Engineers Comments Regarding Surface Water Drainage

Application Reference:	AL/103/25/DOC	Reviewer Reference:	ADC/EXT4
Planning Officer:	Simon Davis	Date of Review:	13/01/2026
Site Name:	Land Adjacent to Woodgate Nurseries Lidsey Road Aldingbourne		
Application Description:	Approval of details reserved by condition imposed under AL/129/21/OUT in relation to conditions 16-Surface Water Drainage Scheme, 17-discharge flows to watercourses and 18-maintenance and management of surface water drainage.		
Assessment Number:	2 of 2

Existing ditch through the site with proposed re-grading levels and culverts
Scale 1:500H / 1:100V @ A1

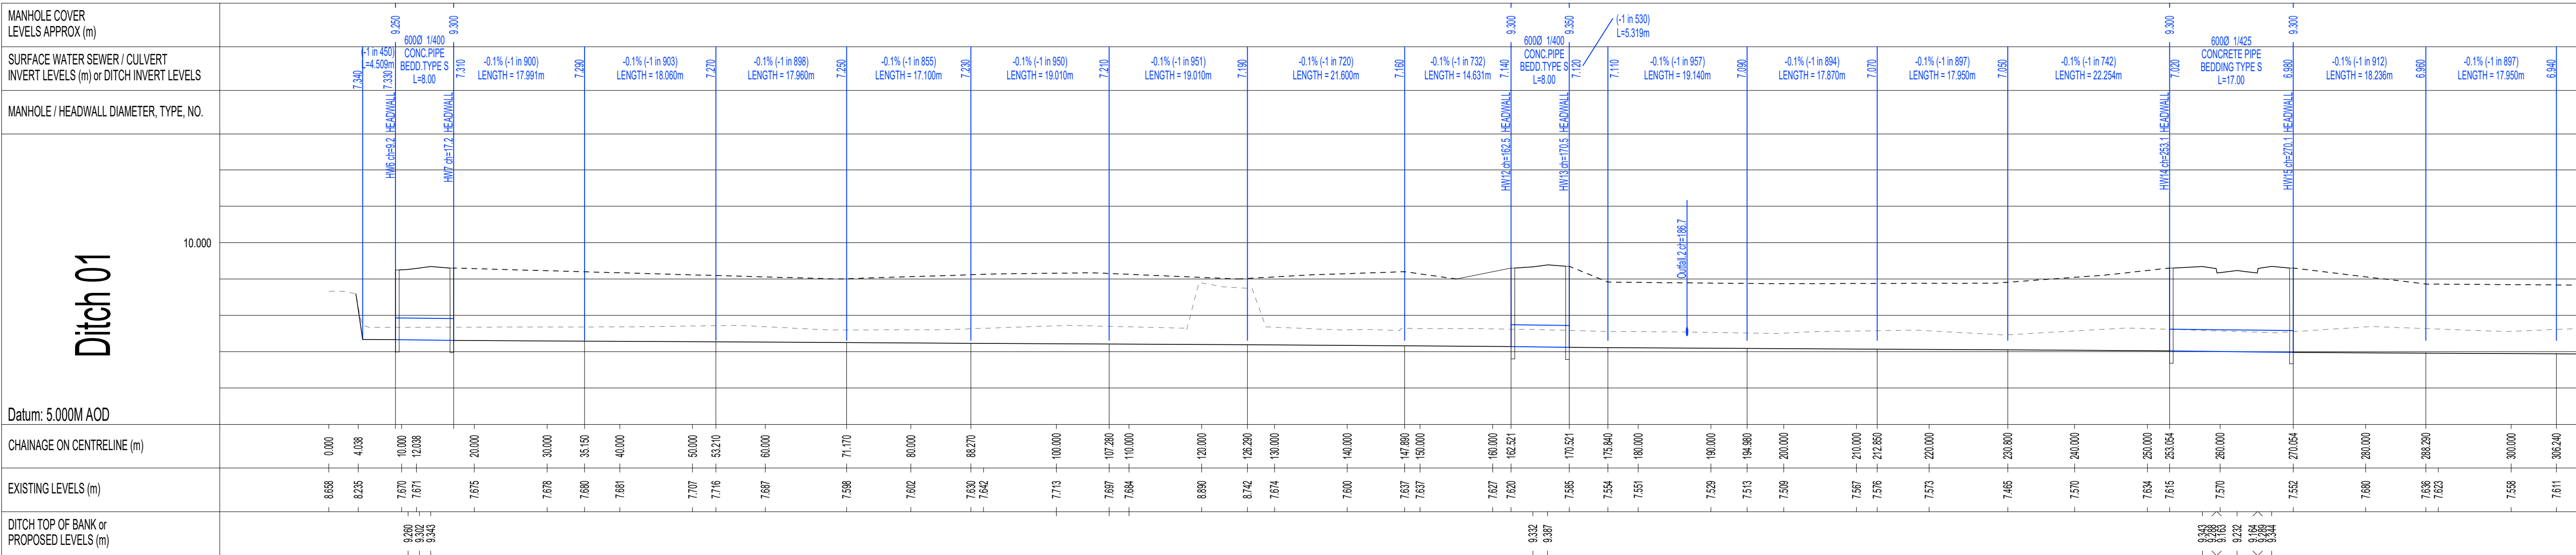
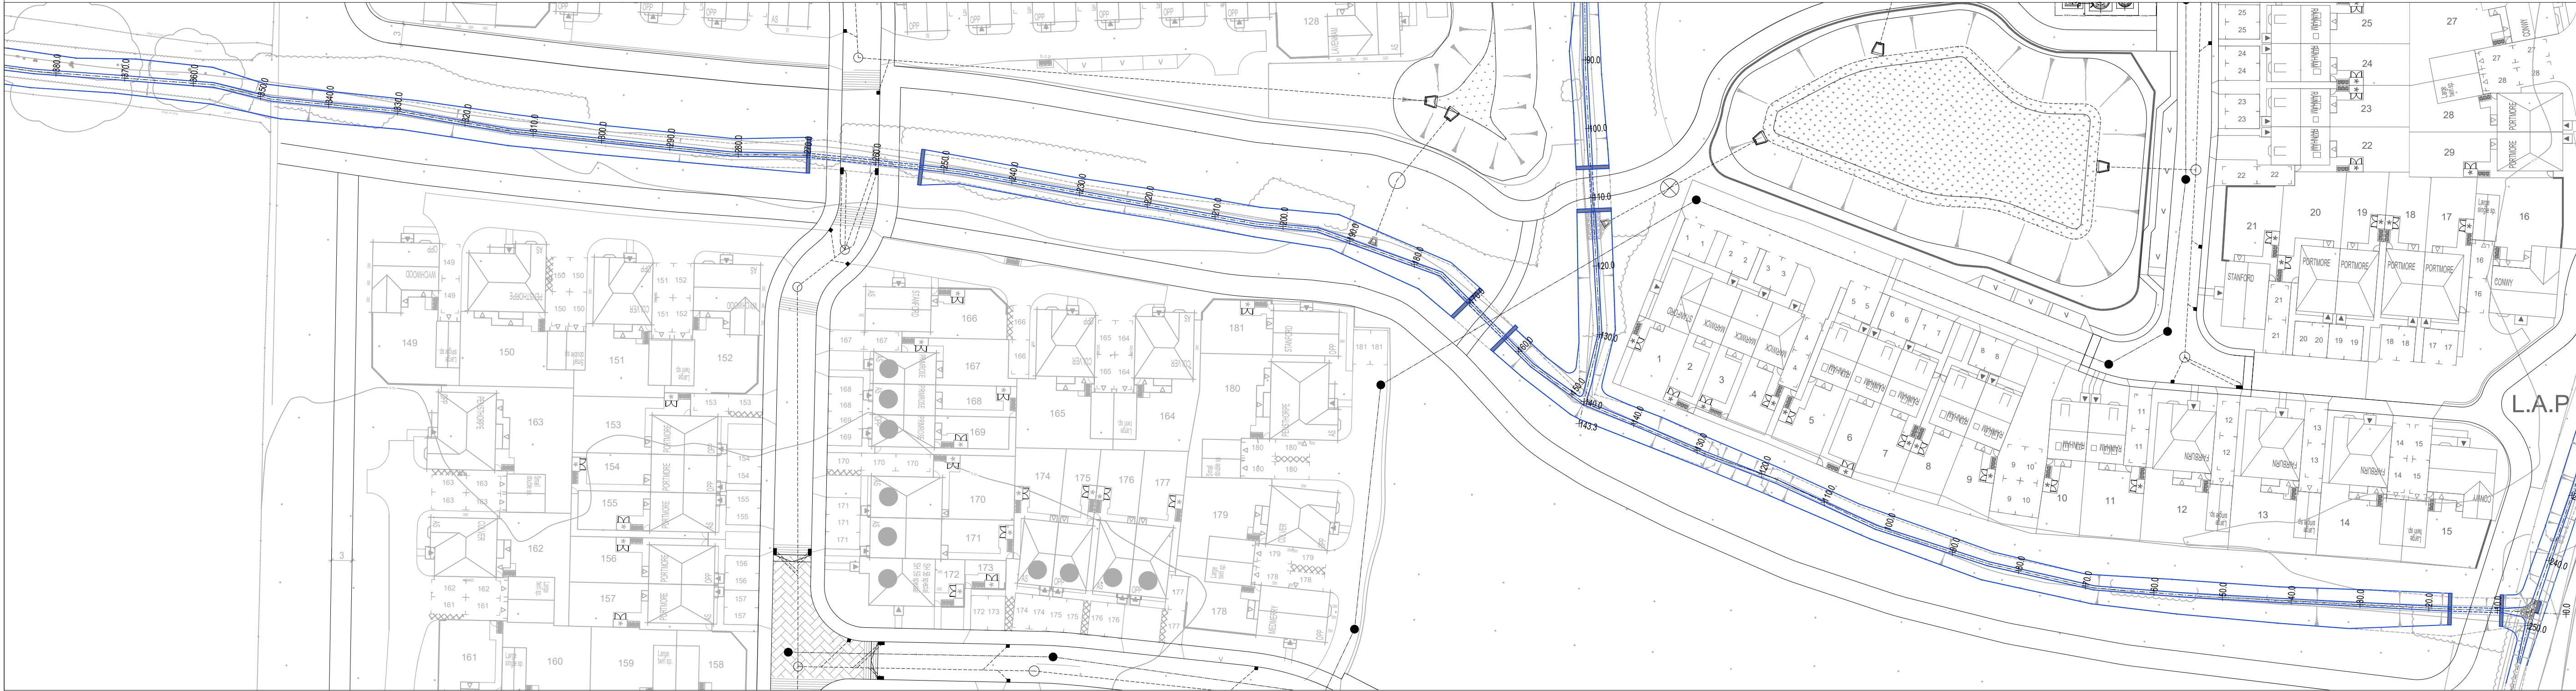
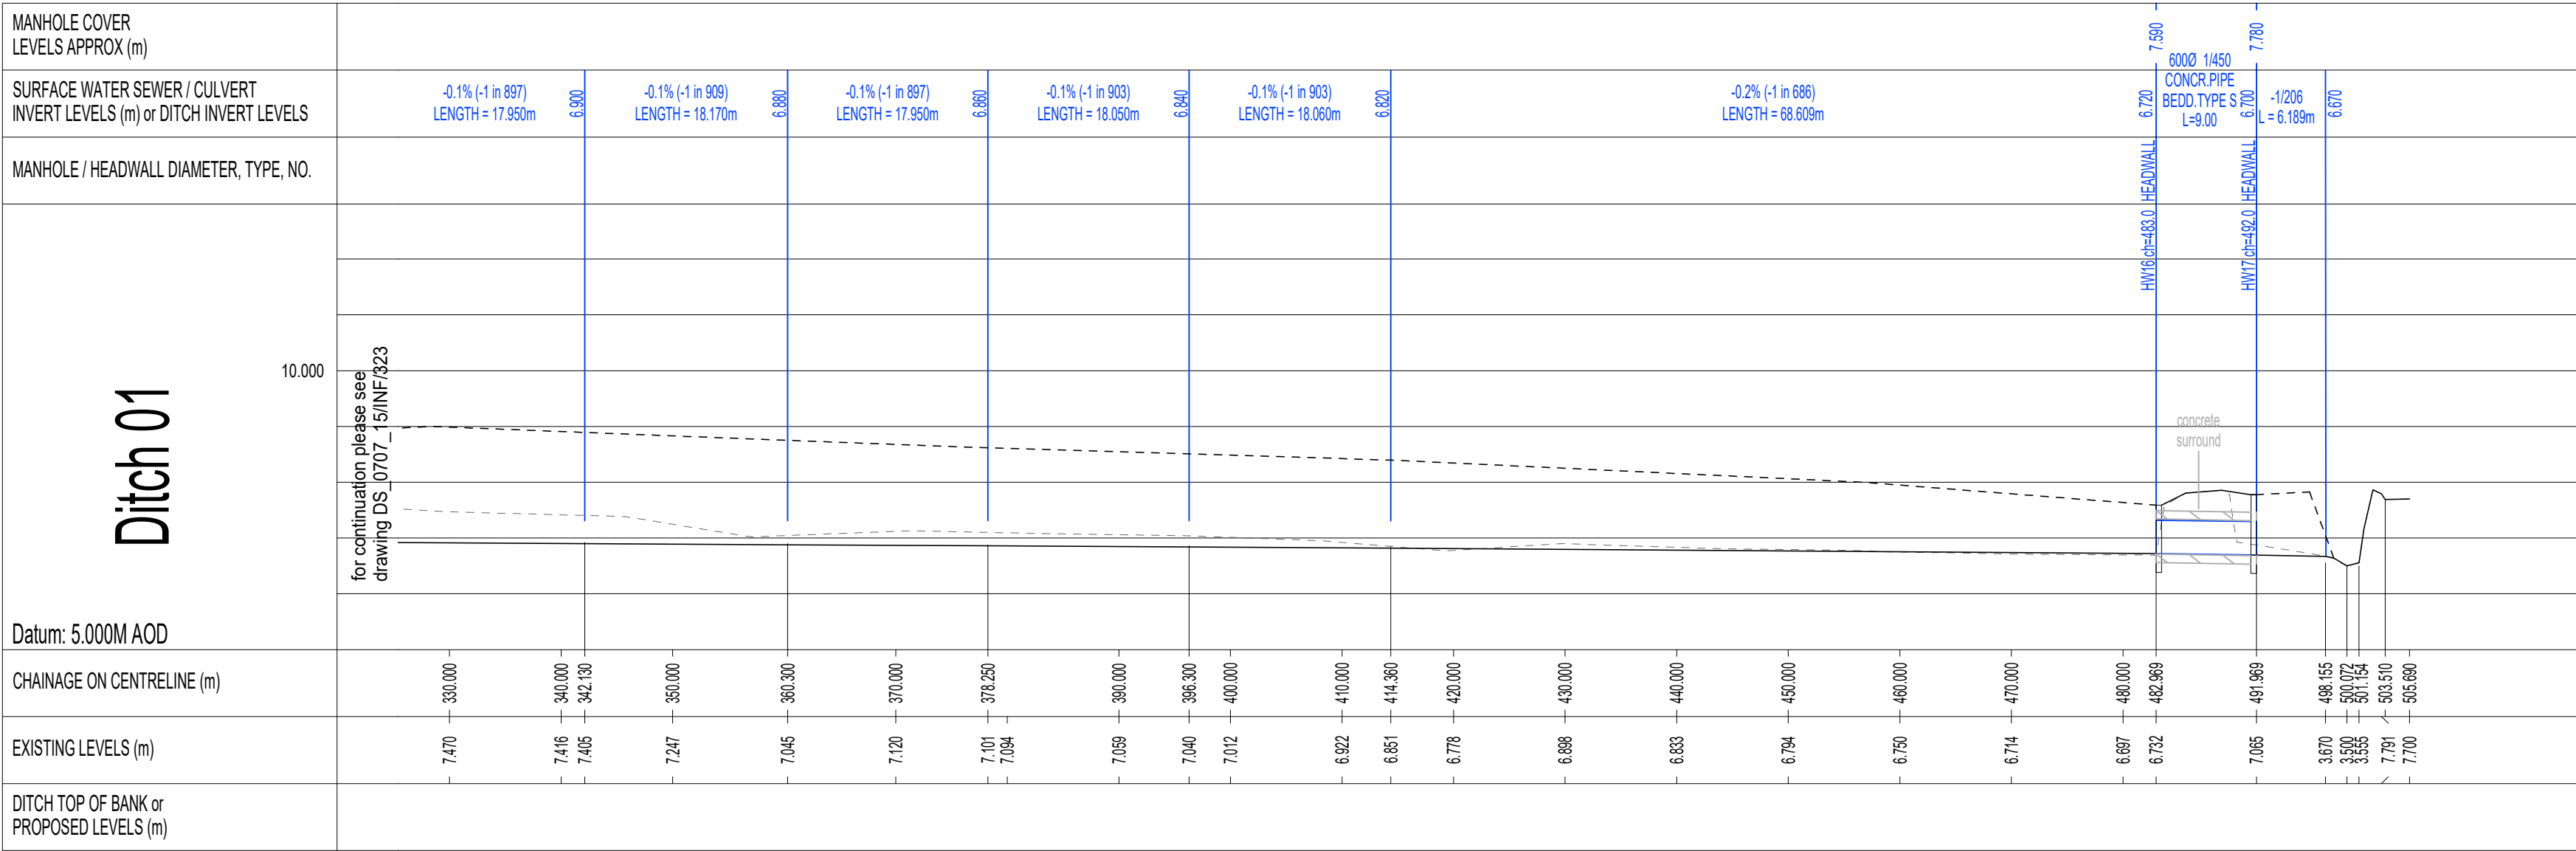
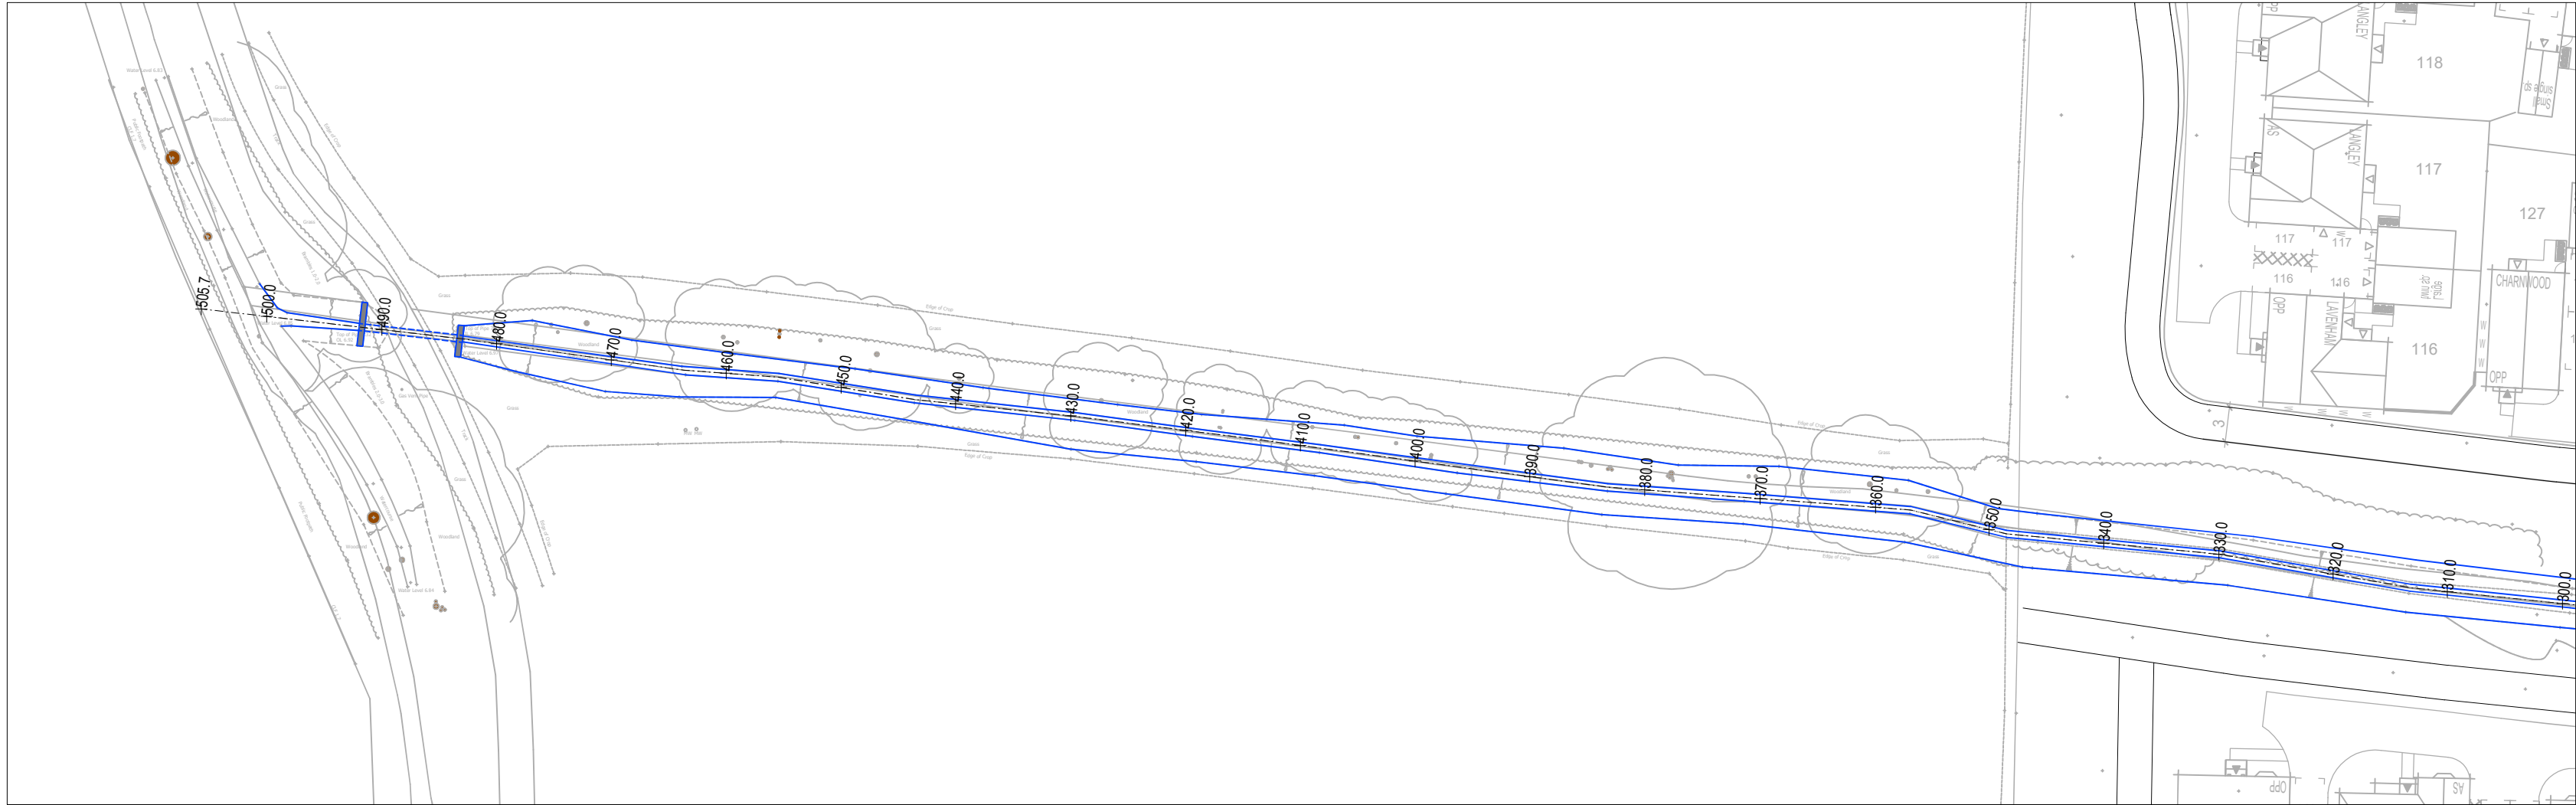
Comment Number					
1	Please note that the proposals for the construction of the new headwall outfalls and culverting of the existing watercourses will require Ordinary Watercourse consents. Please submit the consent to demonstrate no	The drainage layout clearly shows that the headwall encroaches into watercourse, including works to outfall base and erosion control measures. The long section provided noted regrading to the ditch bed level as well. Please	As discussed in recent meeting, Duncan Kier confirmed his view taken as part of the OWC approval that the outfall does not encroach into ditch profile and therefore no OWC was needed He also	Noted item closed

conflict between approved plans. Designer Response 21/10/2025 Please find enclosed Ordinary Watercourse consent for drainage works on the watercourses, that consist construction of culvers / headwalls, regrading of existing ditches. No consent is required for outfall to watercourse as the outfall profile doesn't encroach into ditch profile.	provide construction details of outfall to ditch as well as OWC	confirmed the clearing, de-silting, and regrading of ditches was viewed as watercourse maintenance which also does not require OWC. Within the same meeting		
2	Please provide evidence of positive dialogue in relation to the proposed culvert of the watercourse, in terms of capacity assessments and confirmation of ecological and tree protection impacts or mitigation. Some of the proposed headwalls appear to conflict with existing trees and potentially lie within root protection areas of trees. Please provide details of tree removal plan as well Designer Response 21/10/2025 The ordinary watercourse consent on the culvert has	Provide details of design and drawings which have been approved by this OWC	Approved OWC drawings included in resubmission.	Noted item closed
